OUT18/6463

Bomen Solar Project (SSD 8835)
Comment on the Environmental Impact Statement

Alison Collaros
A/Manager, Assessment Advice
21 May 2018

**Proposal site and study area**

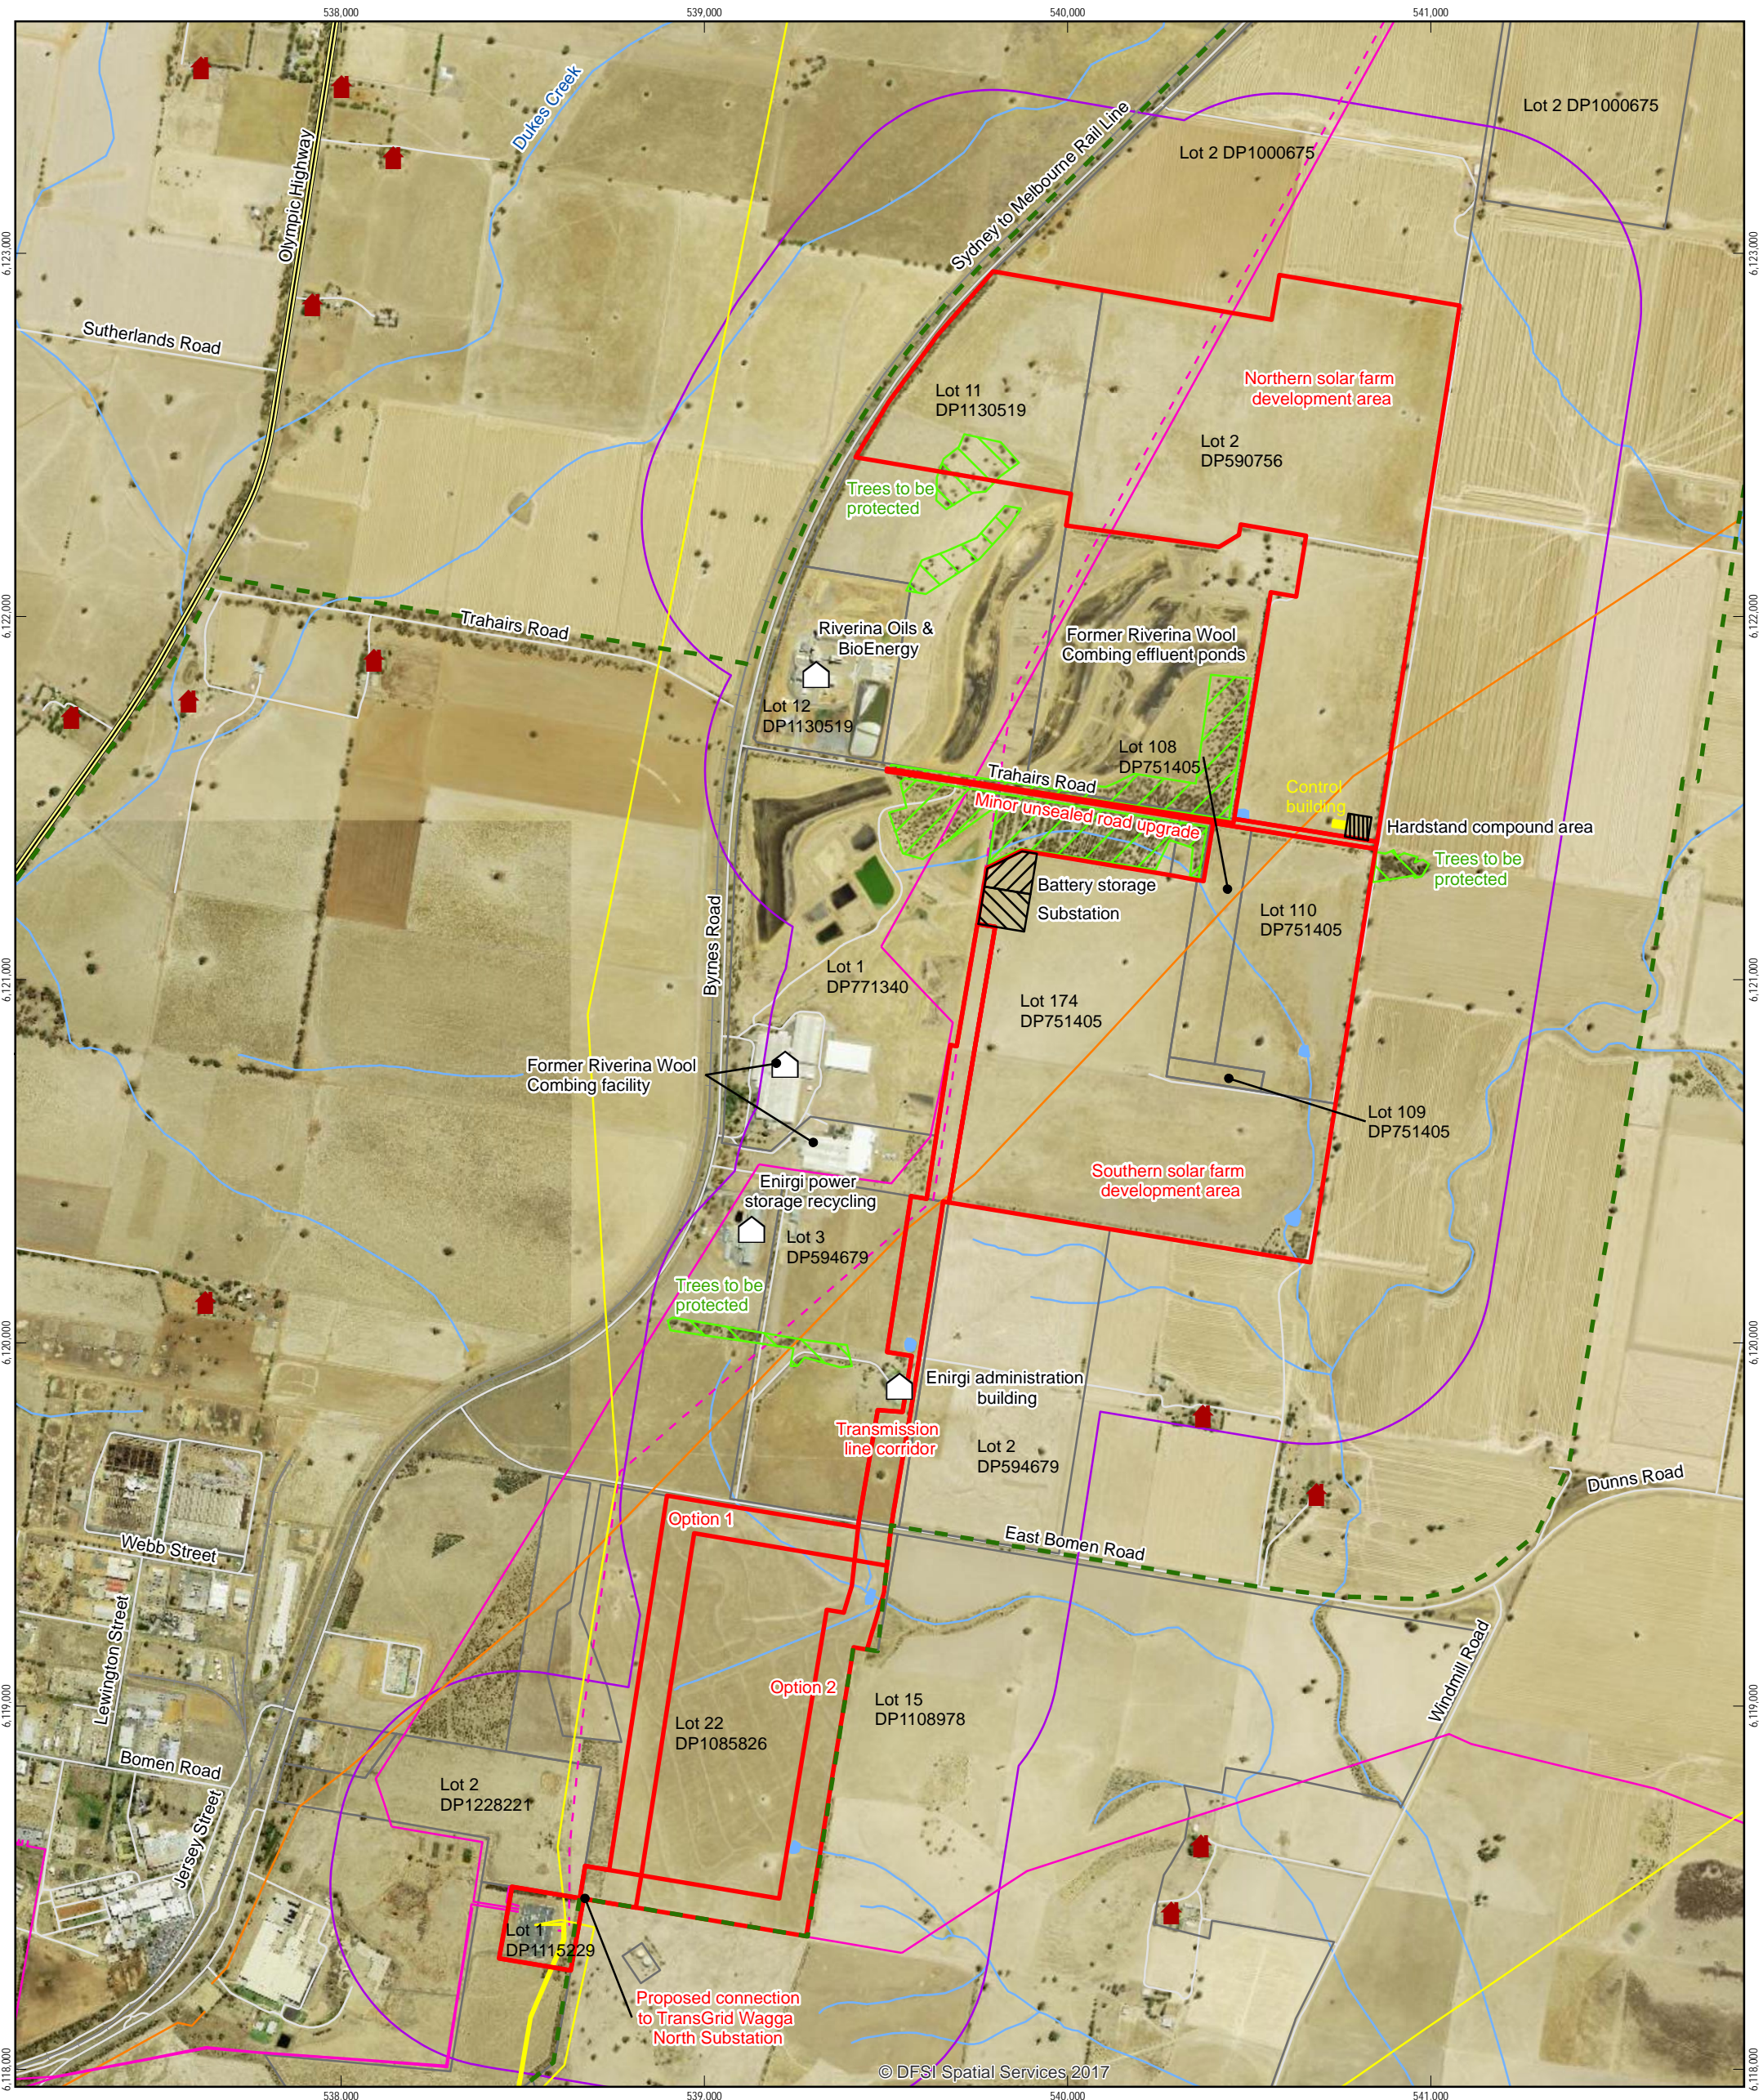
- An assessment should be provided of the impacts of removing dams on aquatic habitat, and the impacts of discharging water stored in the dams. A commitment is requested that rehabilitation of the dams would ensure adequate reconstruction and stabilisation of the drainage channels to address the requirements of the [Guidelines for Controlled Activities on Waterfront Land](#) (DPI 2012).

- An alternative source of water should be provided for operation of the project due to the current reliance on rainfall.
- Clarification is requested of proposed works within waterfront land of the first order watercourse in the southern development area. An impact assessment and proposed mitigation measures should be provided where required. Implementation of buffer requirements to watercourses as detailed in the Guidelines for Controlled Activities on Waterfront Land (DPI 2012) is recommended.

- The proponent has indicated three onsite dams will be decommissioned, however no assessment has been provided of the impacts of removing these dams on aquatic habitat, or on the environment where discharge of the water may be required. The EIS also refers to the potential for construction of additional dams in the future to maintain runoff characteristics if required. If this is proposed consultation will be required with NRAR to determine additional assessment or licensing requirements. Rehabilitation of the dams will need to ensure adequate reconstruction and stabilisation of the drainage channel.
